## PLANNING CONSULTATION RESPONSE

<b>Application No</b>	2026/0355
<b>Proposal</b>	(RETROSPECTIVE) Variation of condition 2 (Approved Plans) of application 2024/0699: Demolition of existing buildings and erection of 5no. bungalows, formation of new access and associated works.
<b>Address</b>	Royston Working Mens Club, 52 Church Street, Royston, Barnsley, S71 4QU
<b>Date of Consultation Reply</b>	27/05/2026
<b>Consultee</b>	Katie Lawrence, Planning Ecologist

Drawing  
Title:  
SITE PLAN

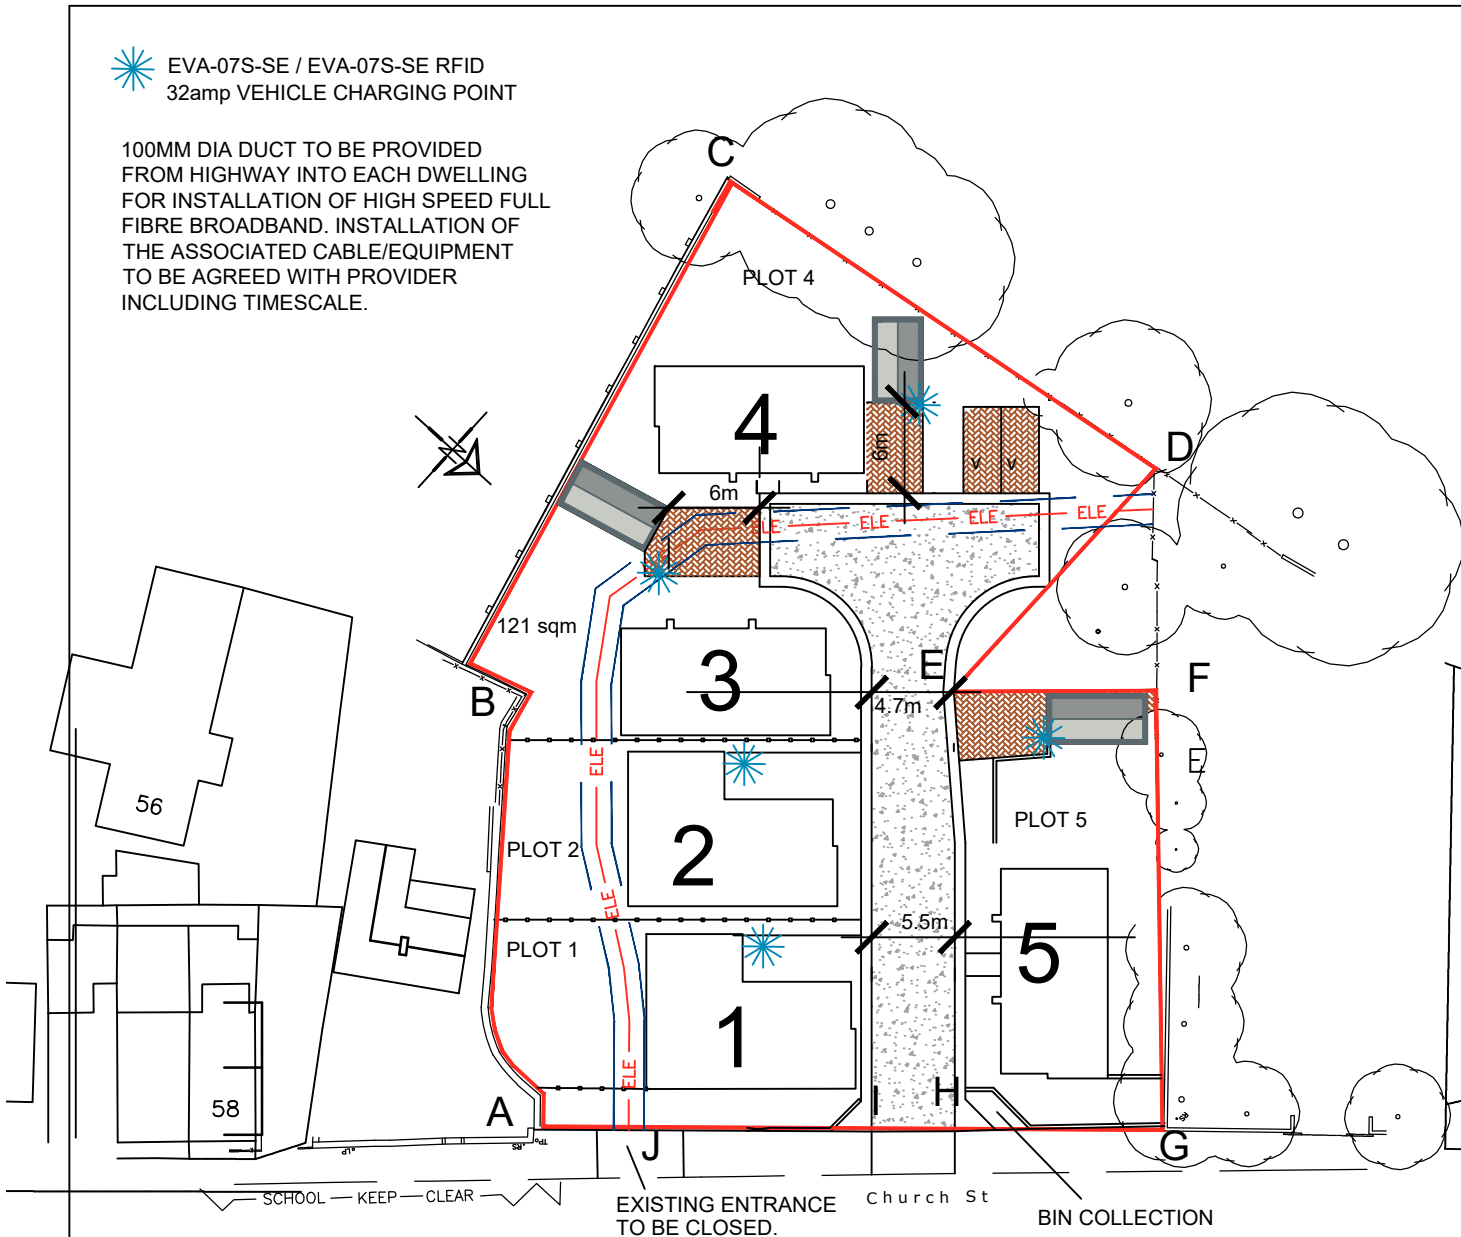
Thank you for consulting me regarding the above application. Minor changes have been made to the site plan, and it is noted that these changes affect an area proposed as wildflower grassland to the north-west of the site. An amended Biodiversity Gain Plan, biodiversity metric and Habitat Management and Monitoring Plan should be submitted which take these changes into account to ensure that the site still meets its Biodiversity Net Gain requirements and any changes to areas where management and monitoring is required.
